22 September 2021

Karen Harragon
Director, Social and Infrastructure Assessments
School & Infrastructure Assessments
NSW Department of Planning, Industry and Environment
4 Parramatta Square, 12 Darcy Street Parramatta 2150

RESPONSE TO SUBMISSIONS UNSW HEALTH TRANSLATION HUB (SSD-10822510)

drawing
Shadow Analysis

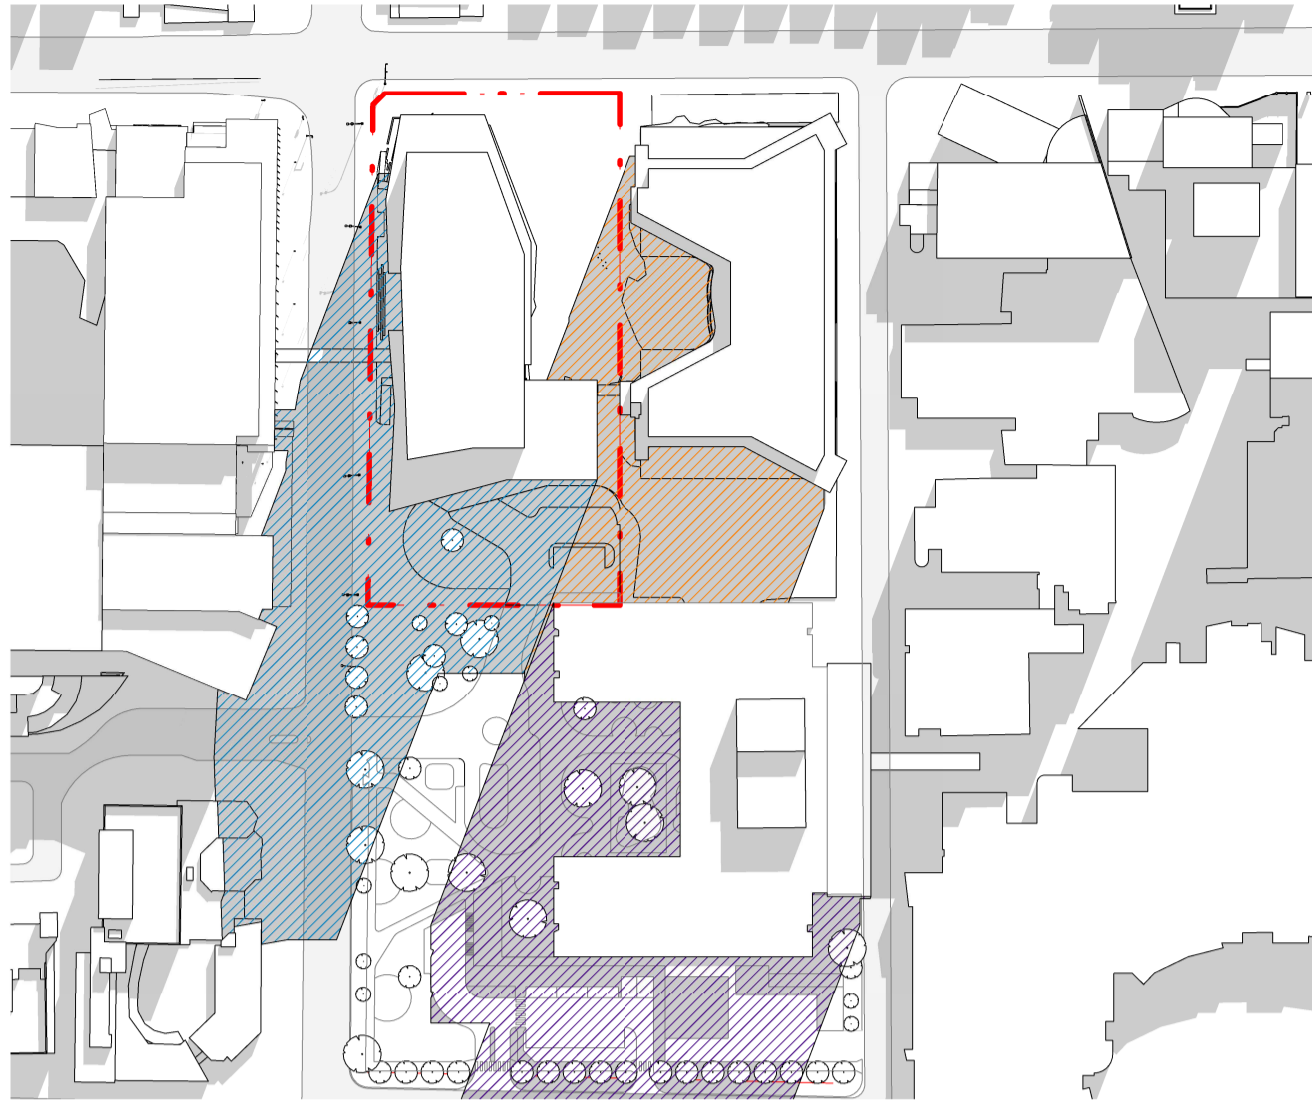
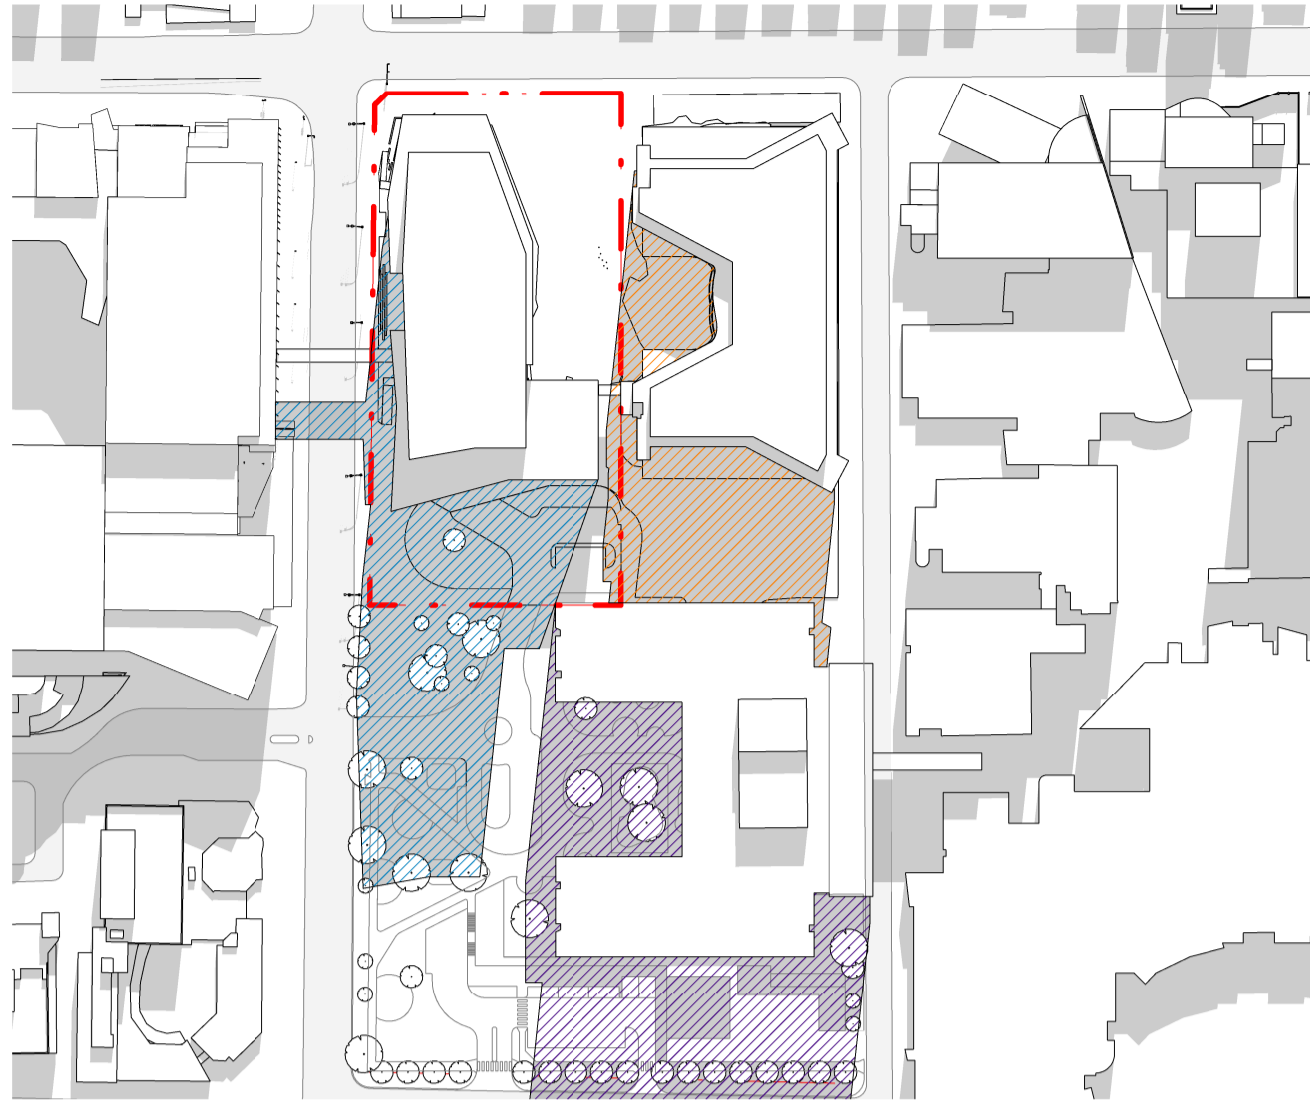
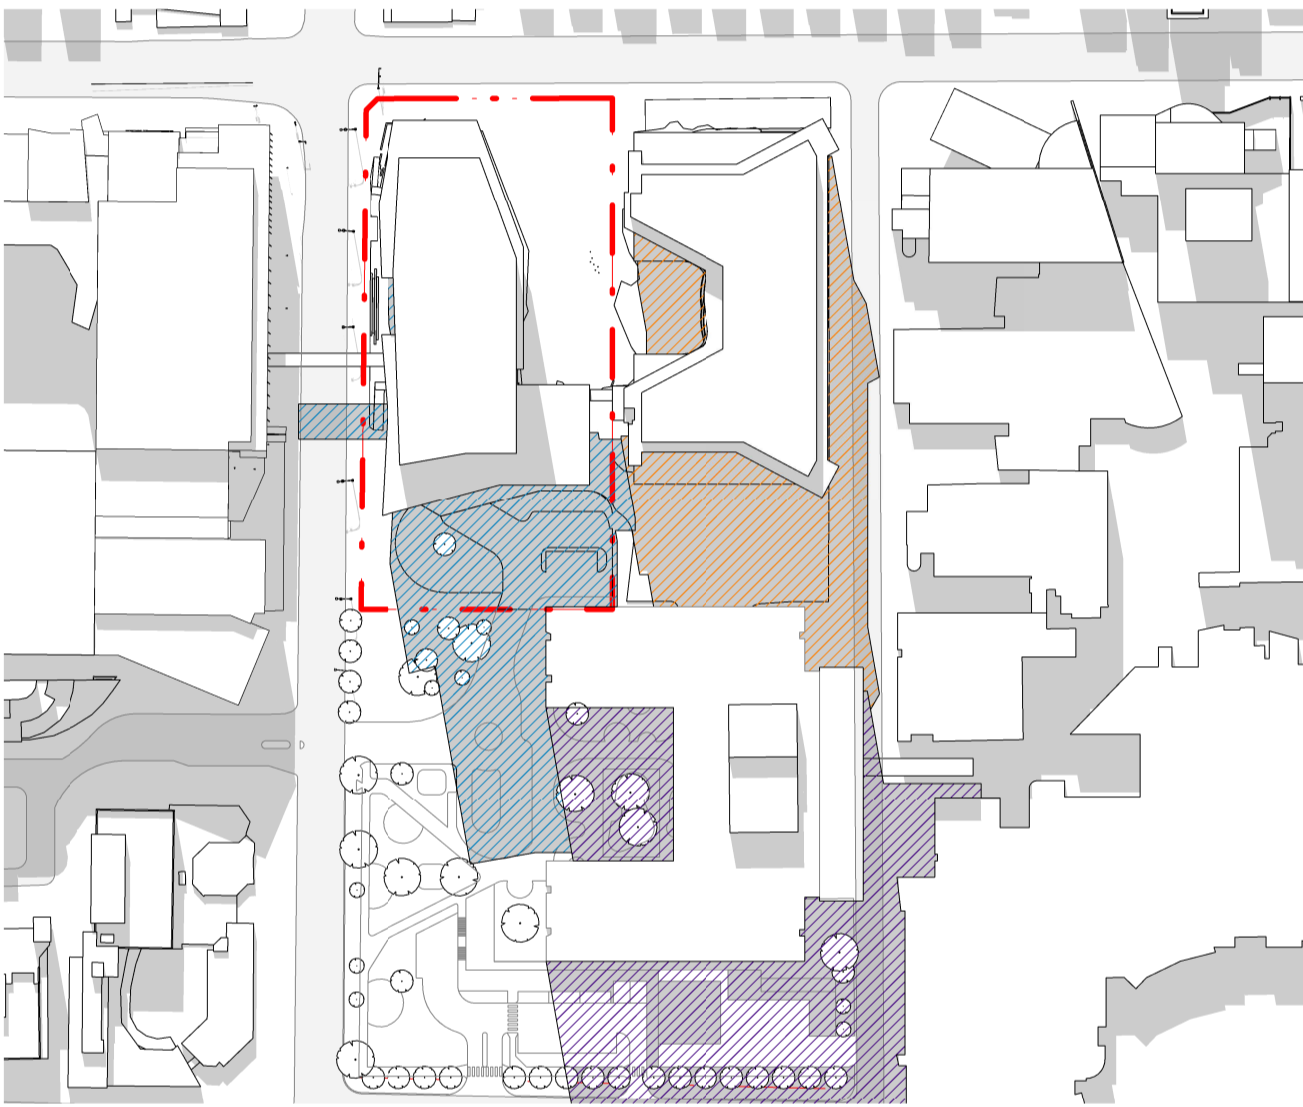
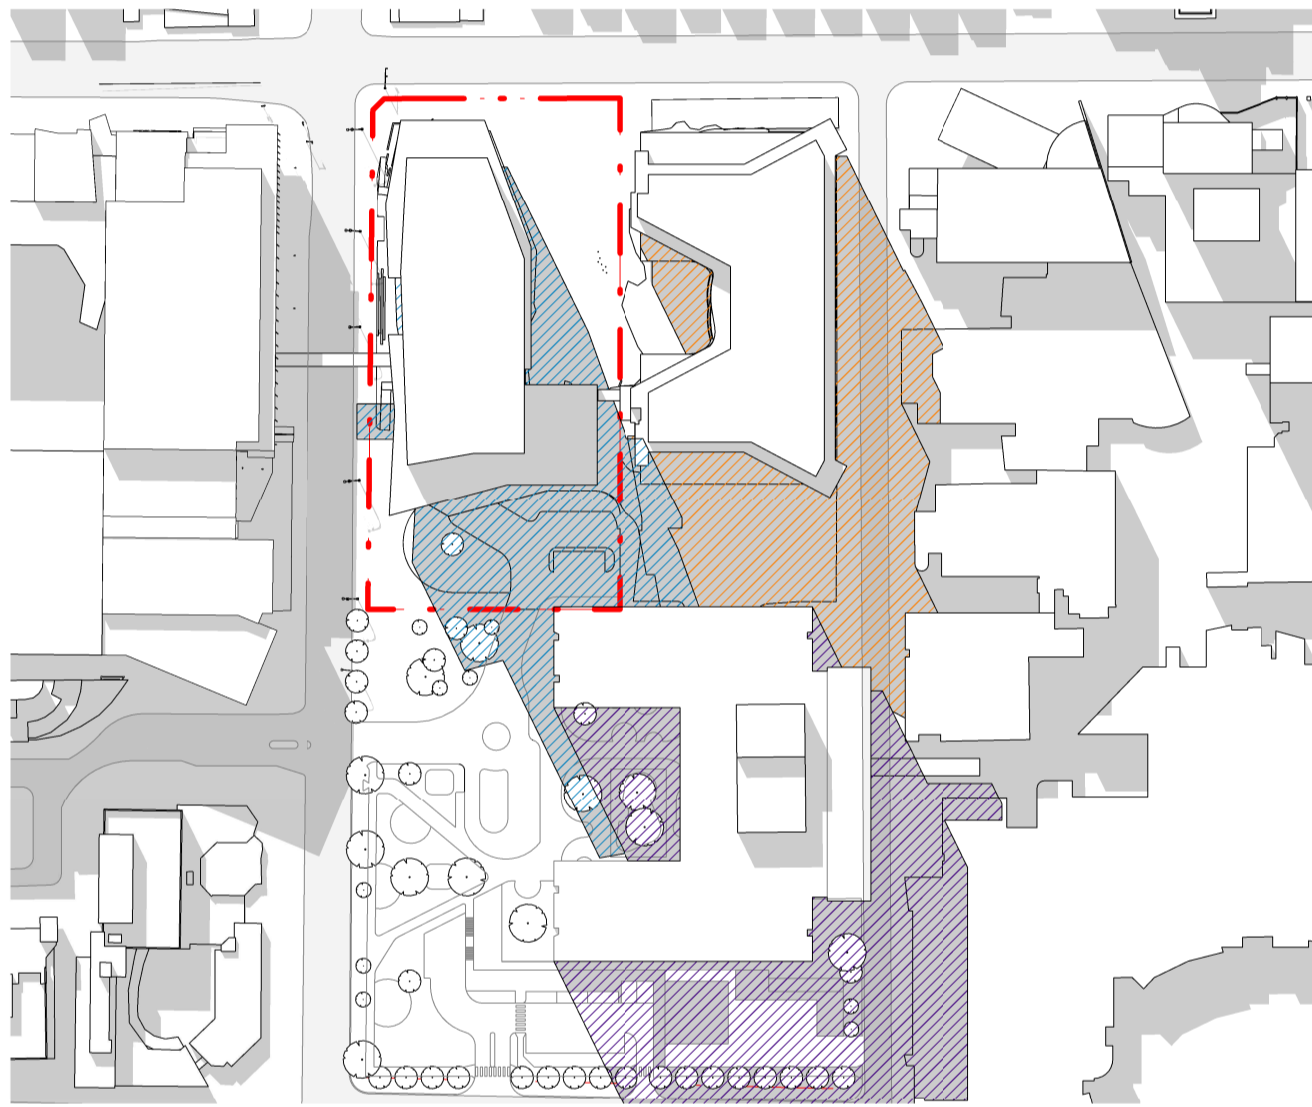
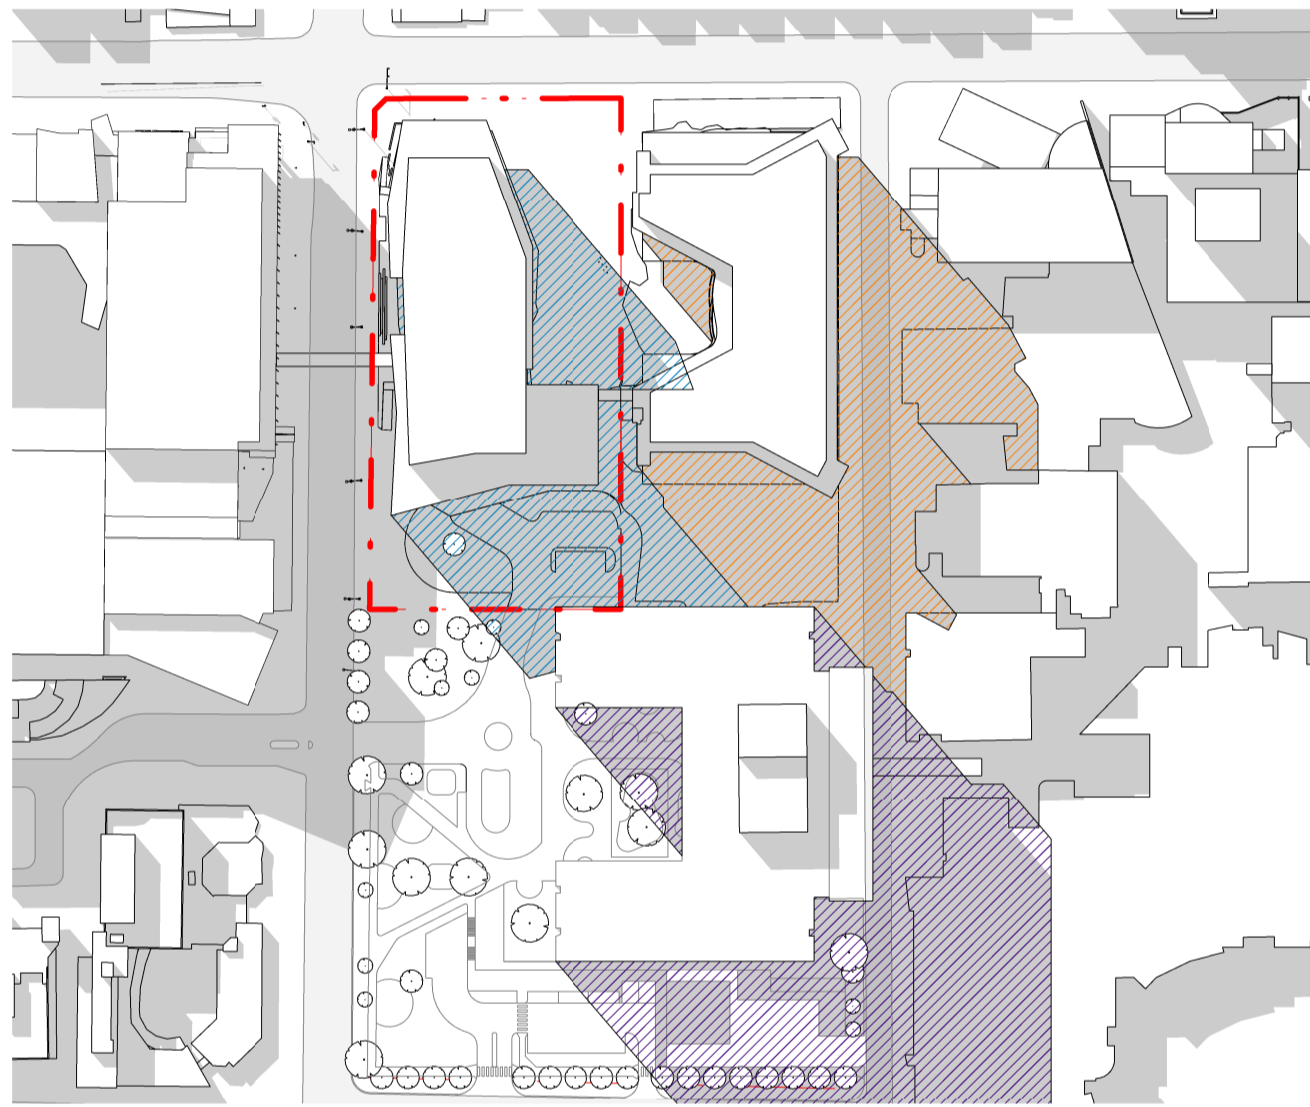
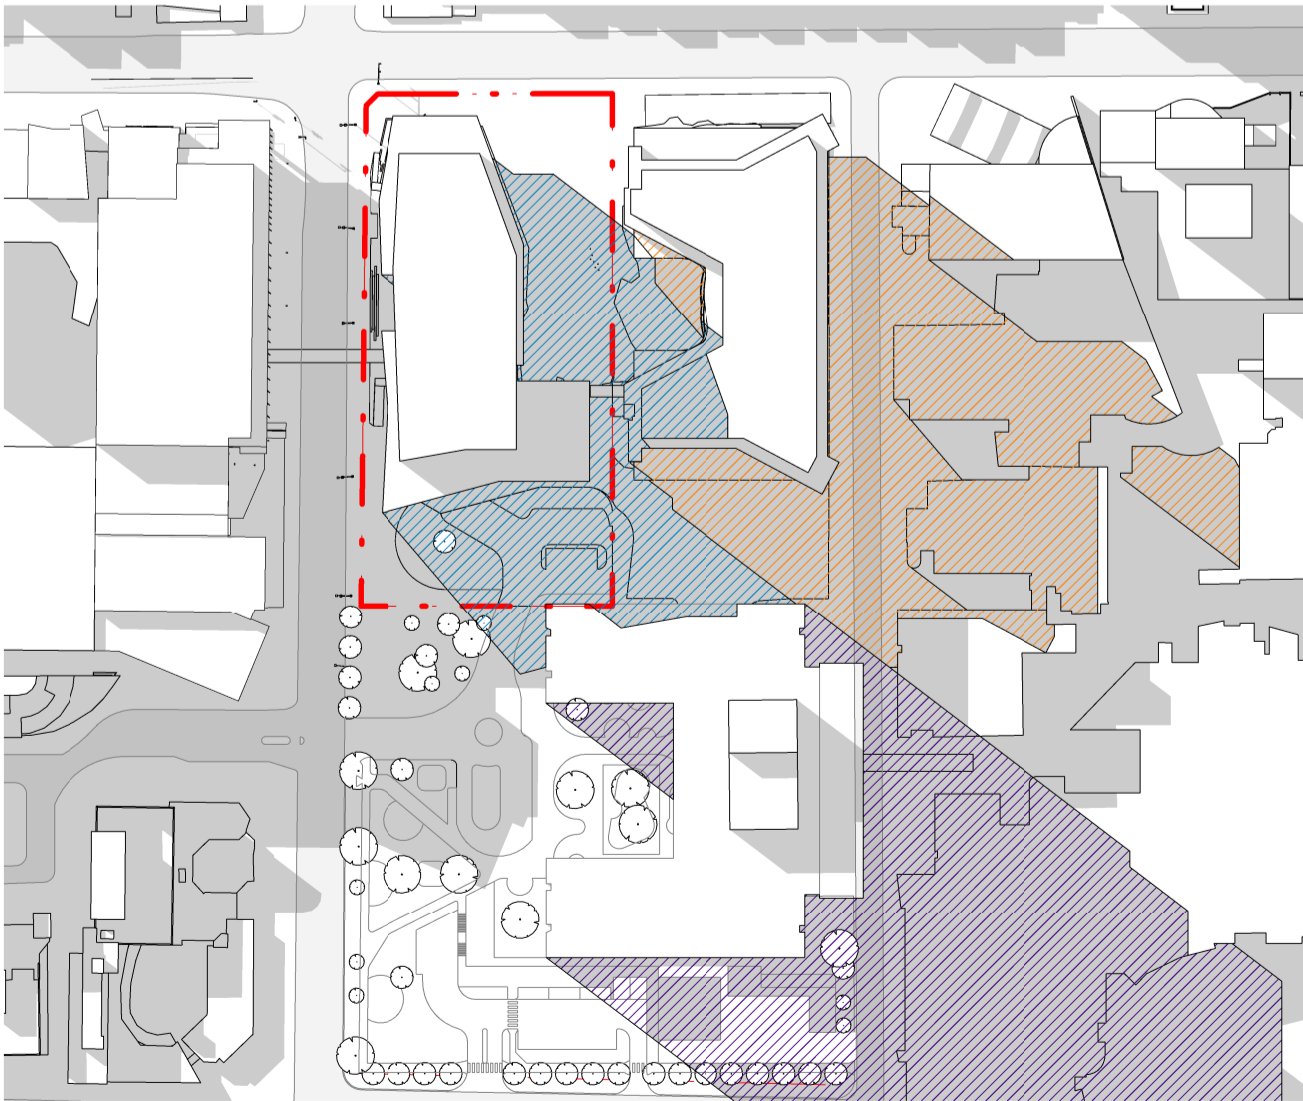
Council has requested hourly shadow diagrams at June 21 to demonstrate the overshadowing impact of the UNSW HTH on the IASB forecourt and main hospital vehicular drop-off / pick-up, which Council has identified as providing an important new green space along Botany Street for the enjoyment of Randwick Hospital, the UNSW campuses and the broader Randwick community. Council has noted that it appears as though the southern leg of the UNSW HTH will overshadow the Children's Hospital emergency vehicular drop off loop and pedestrian waiting area for most of the winter months.

In response, Architectus has prepared hourly shadow diagrams at June 21 (refer to **Attachment A** and **Figure 4**). The shadow diagrams distinguish between shadows cast by the UNSW HTH, SCH Stage 1 and CCCC and the IASB. They also show the location of the internal road network and vehicular drop-off / pick-up. The summary below demonstrates the, on balance, the shadow cast by the UNSW HTH on the green space along Botany Street is acceptable as it does not cast significant shadow on this space between 12:00pm and 3:00pm on the Winter Solstice.
